**WEST SUSSEX COUNTY COUNCIL
STRATEGIC PLANNING CONSULTATION**

DATE: 12/10/2011

SUBJECT: A/129/11 - New dwelling replacing mobile home. (This application is a Departure from the Development Plan).

Foschini's Nursery, Hangleton Lane, Angmering, West Sussex, BN12 6PP

project	house at FOSCHINI'S NURSERY HANGLETON LANE BN12 6PP
client	Mr & Mrs G L Foschini Hangleton Lane Ferring WORTHING
agent	Peter Wilson Hilary Mount Way Lancing Sussex BN15 0GD 01903 755765
drawing	scale 1:2500 @ A4 date: 22/08/11 revision tp675/9

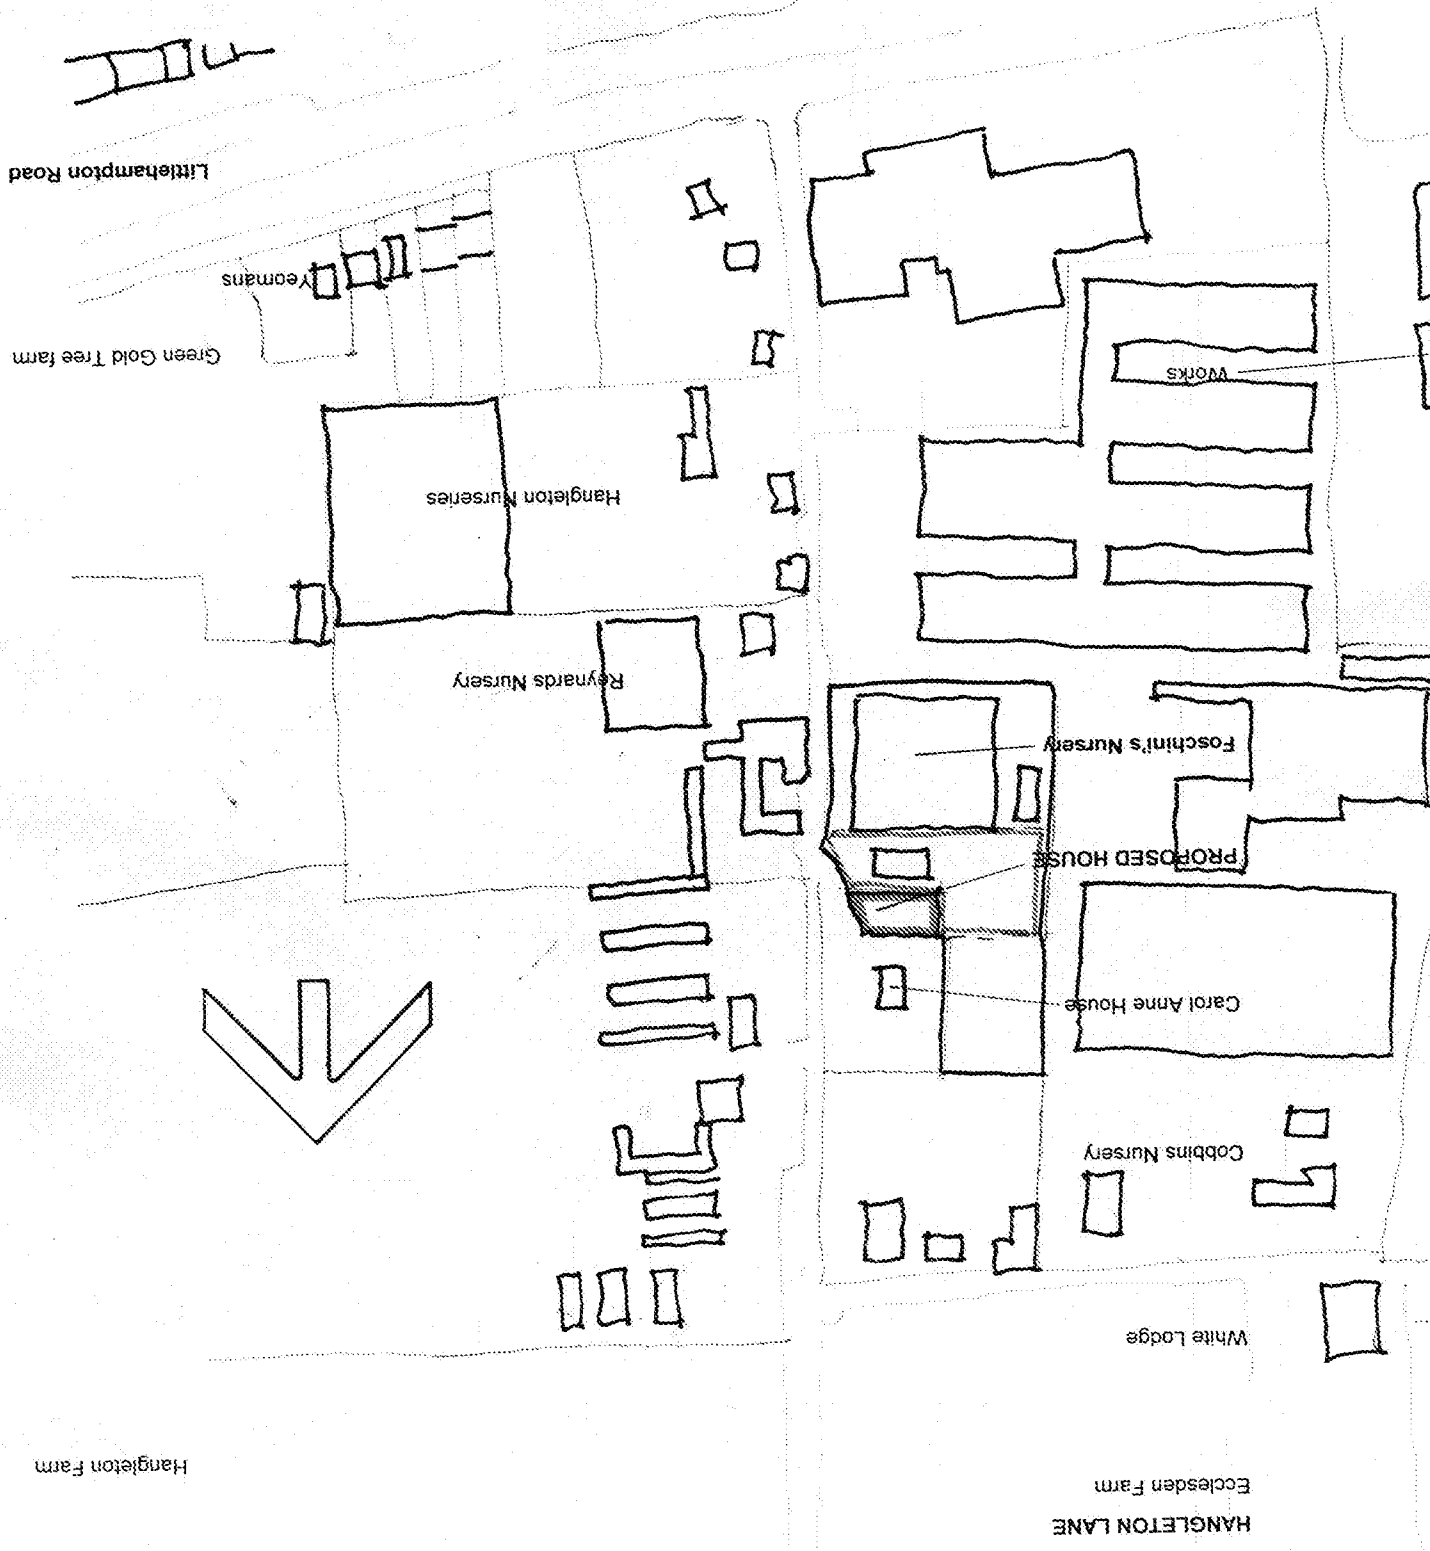
Access to the property will remain the same and be made form Hangleton Lane. Visibility to the north is restricted due to an existing boundary hedge, however it seems that traffic movement to the north of the site is minimal. It should also be noted that this assess has served the temporary dwelling and nursery for many years and according to recent accident reports has done so safely. Once the development has been completed I would not expect there to be an increase in vehicular activity given that the property will be being used for the same purpose only on a permanent basis.

From inspection of the plans it appears that there will be enough room to park 3 cars as outlined in the application. This meets the current WSCC minimum parking standards for a development of this size. However this parking provision has not been specifically outlined in any of the plans provided.

If the LPA are minded to grant permission for this application a condition for vehicle parking and turning should be included.
